**To:** Janet Hansen/SMRT – Brent Poulin/Cainbro  
**From:** Mike Nugent/Manager of Inspection Services  
**Date:** 08/18/2003  
**Re:** 65 India St. (020 E020) Vertical Expansion

## Final questions

G7 EAST ELEVATION

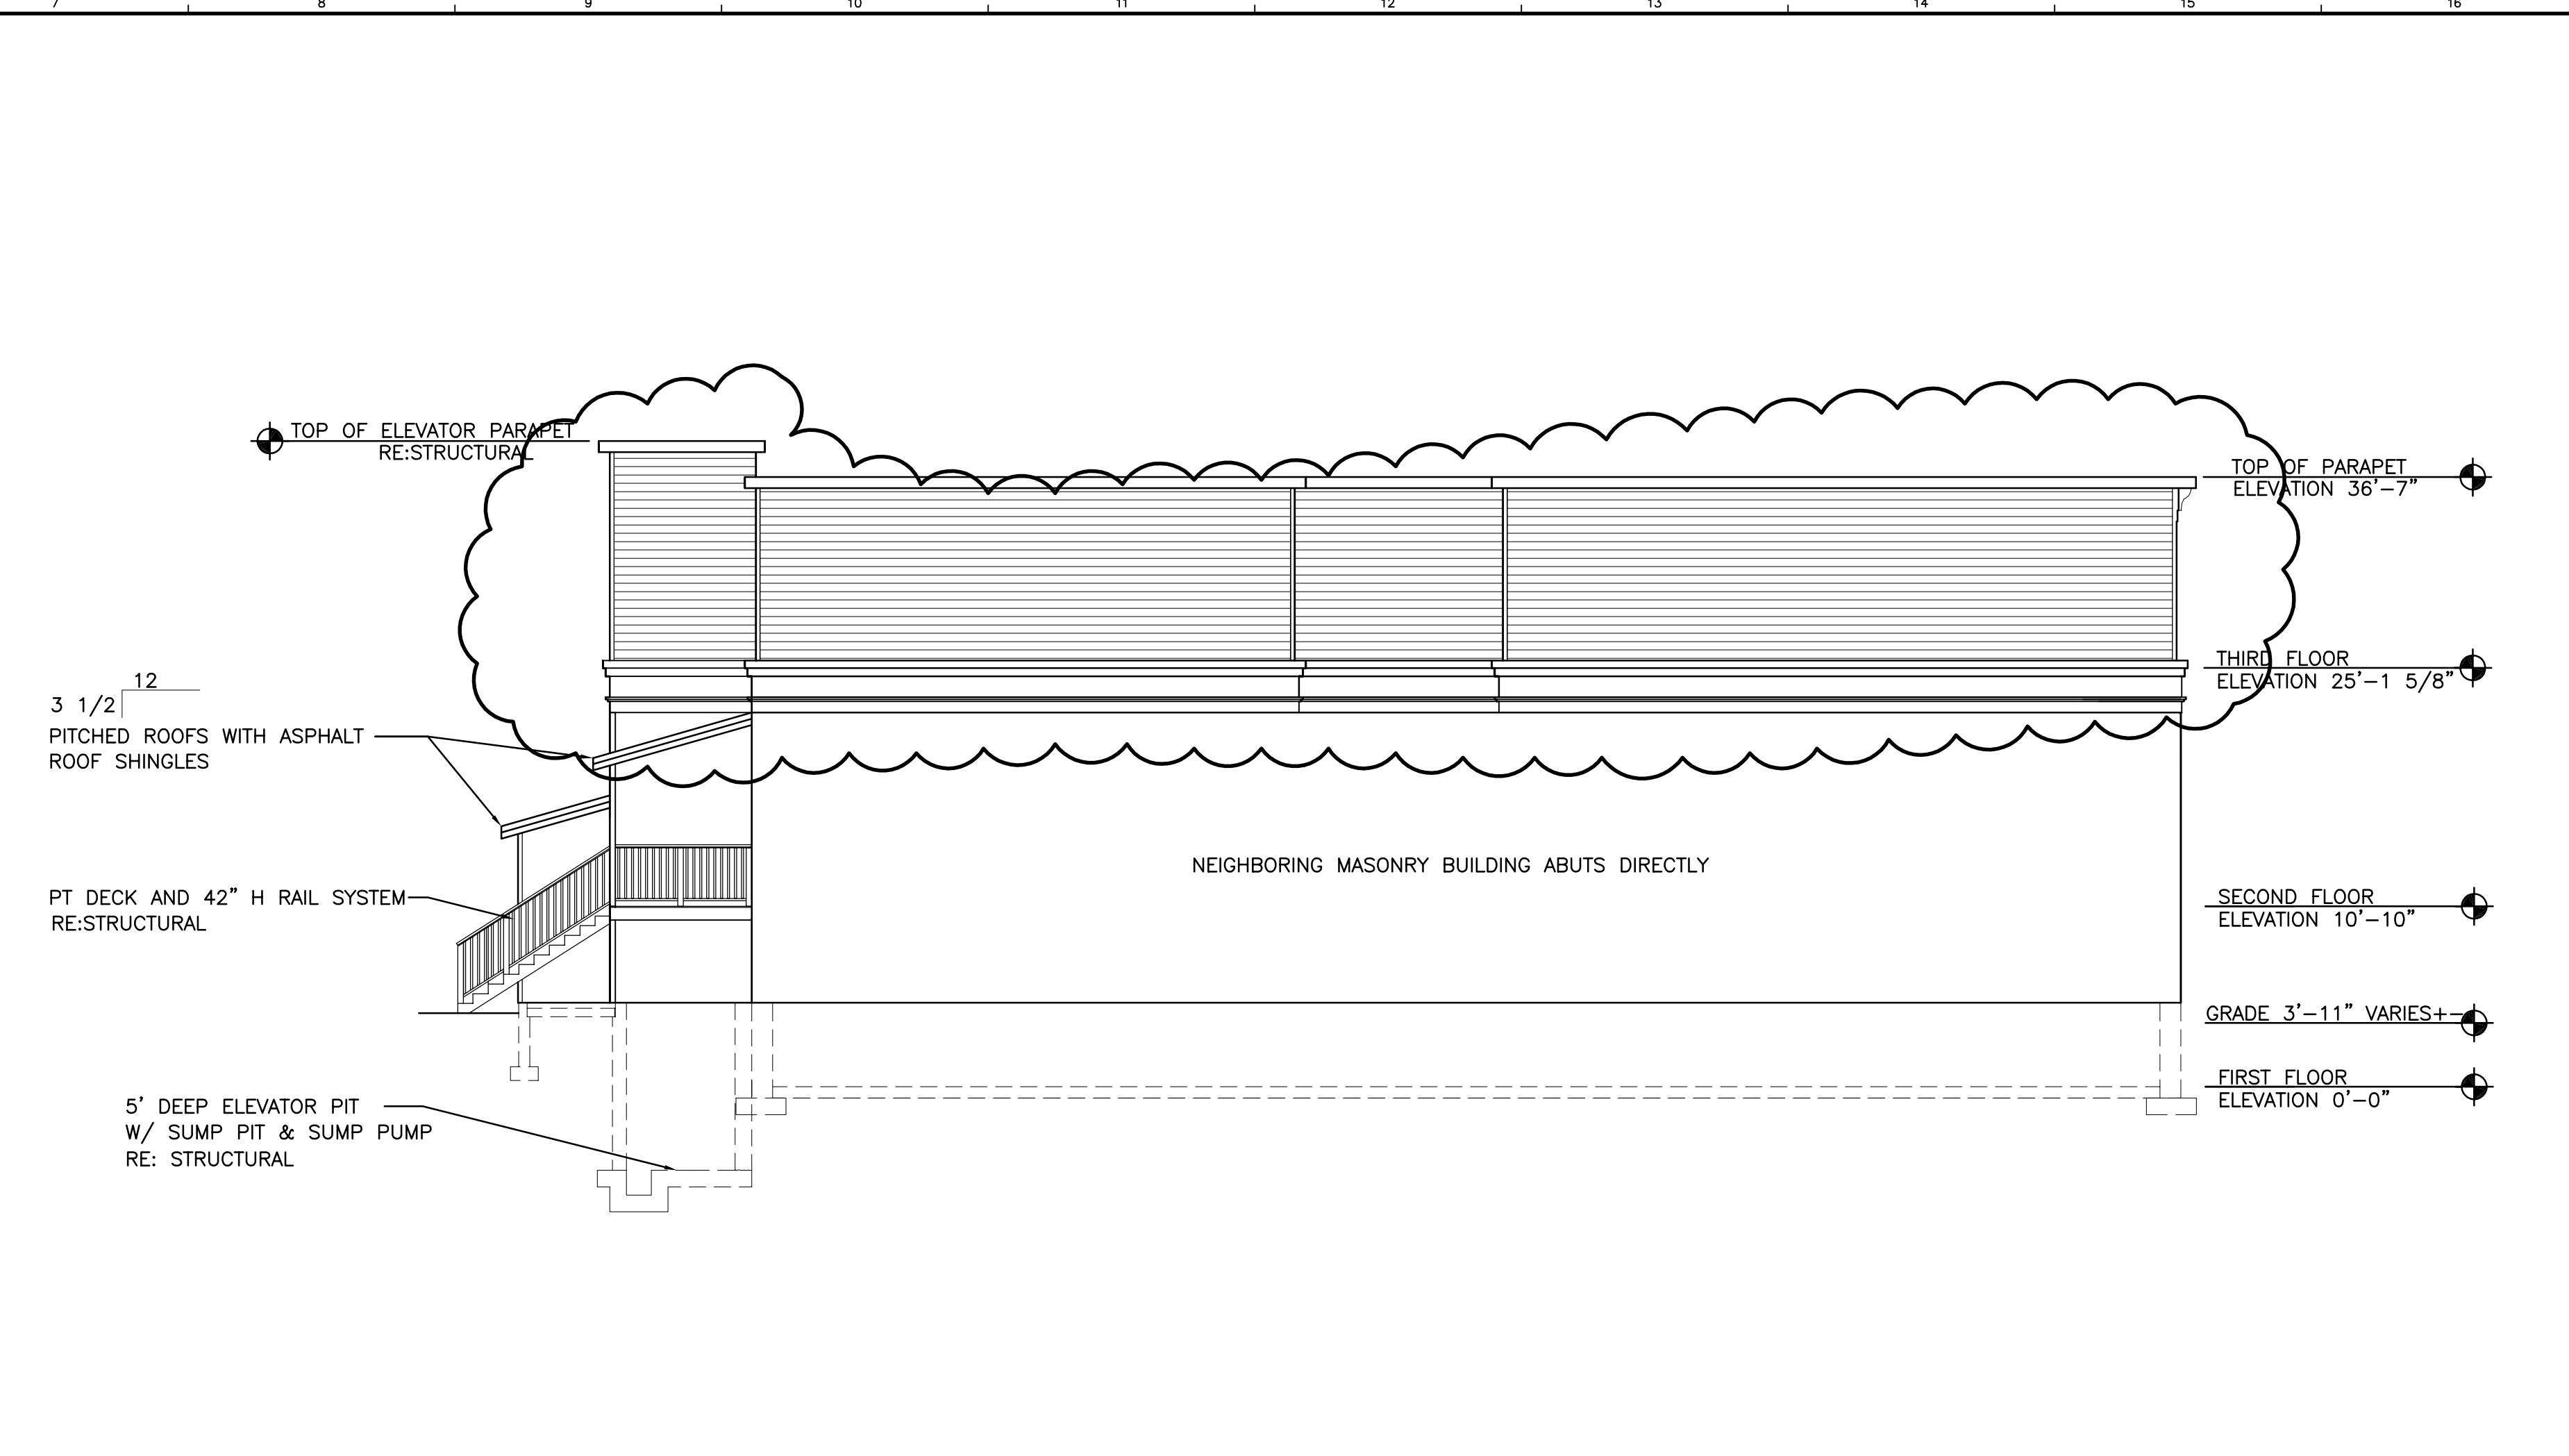
- 1) It appears that the new rear walls and stair towers on the East elevation are within 5 feet of the property lines. Your proposal shows a type “2” wall which has a 1 hour rating, this must be 2 hr.
- 2) What is the rating of the roof system?
- 3) I see references to your tread dimensions but not the risers. Where can I find that?
- 4) The letter from the engineer certifying the ability of the old structure to hold the new one? Can't seem to locate that in the “pile”
